Subject: FAO Mrs A Gardner: Highways England response (our ref #87535) re. A/177/19/PL - The Vinery

Planning Application No: A/177/19/PL

Site: The Vinery, Arundel Road, Poling, BN18 9PY

Proposal: New building for storage or distribution, light industrial & office (Class B1/B8) & associated parking. This application is a Departure from the Development Plan & may affect a Public Right of Way.

drawing No: 19011-A-PL-007 revision: A

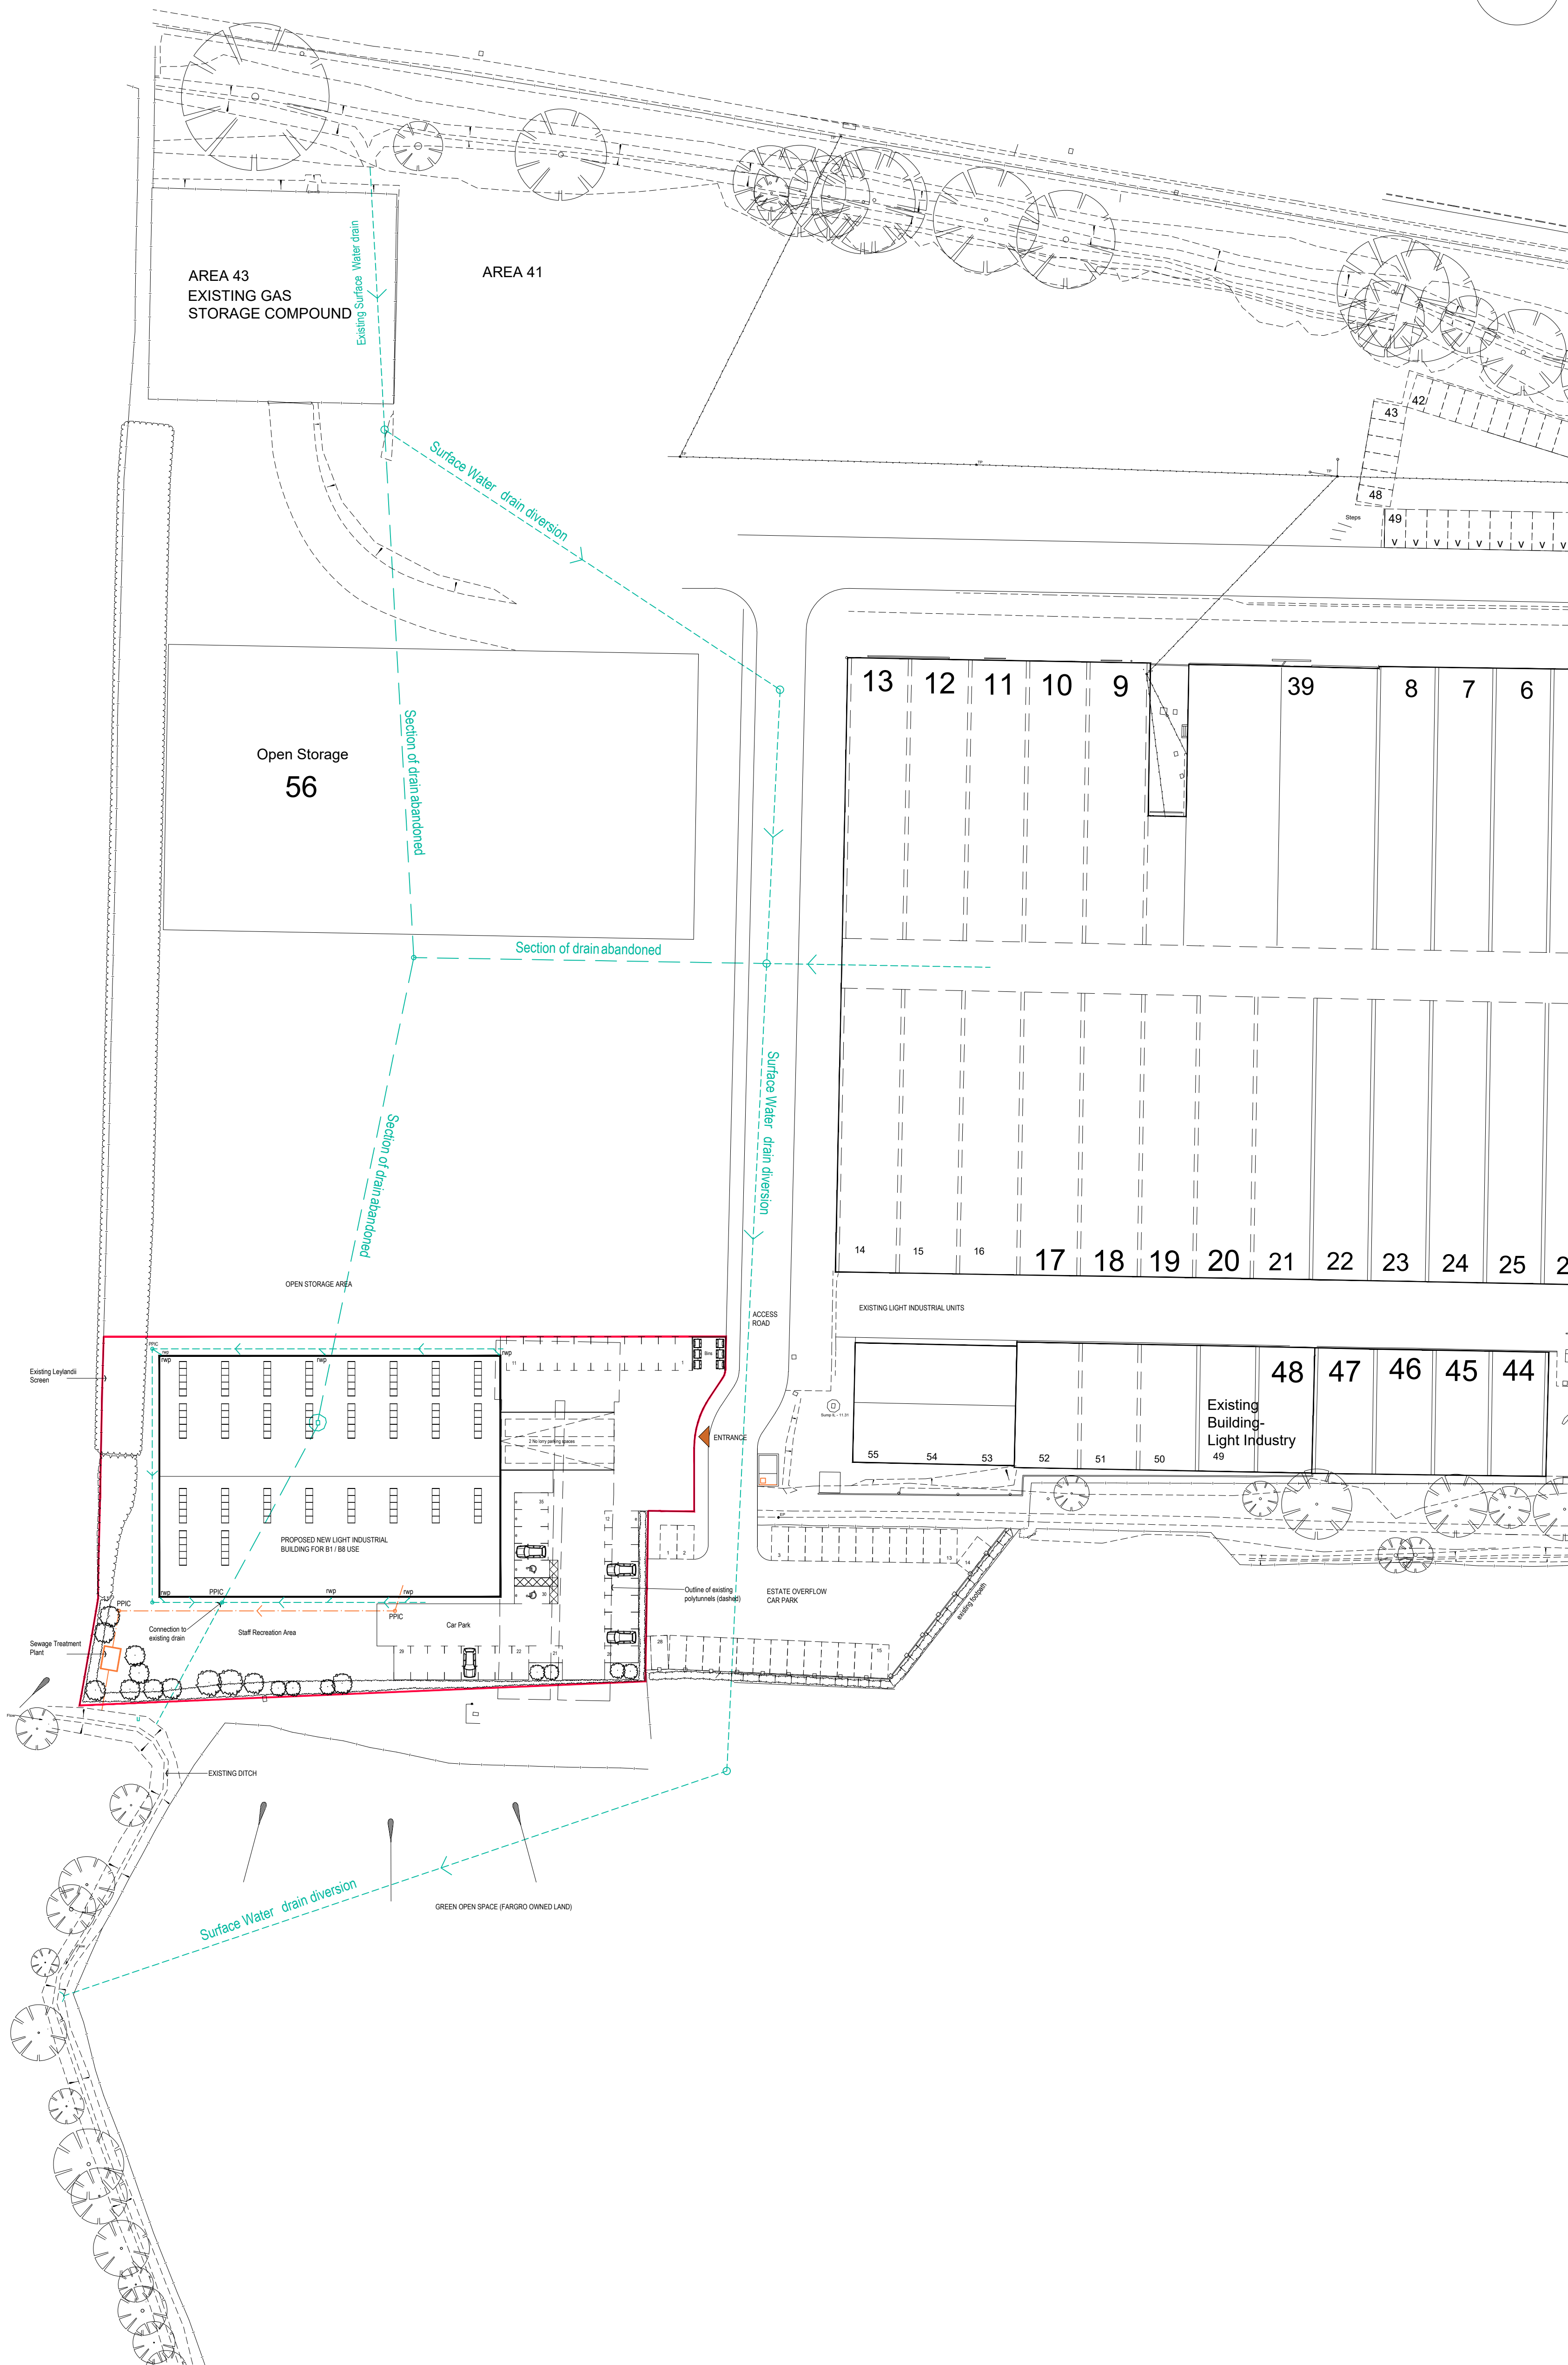
- 1) No new connections or increase in discharge shall be permitted to the diverted surface water drain as shown on Vision Architects' drawing "*19011-A-PL-007 revision A - Proposed Drainage Layout*", while existing maintenance access rights will be maintained following the proposed diversion and in perpetuity.
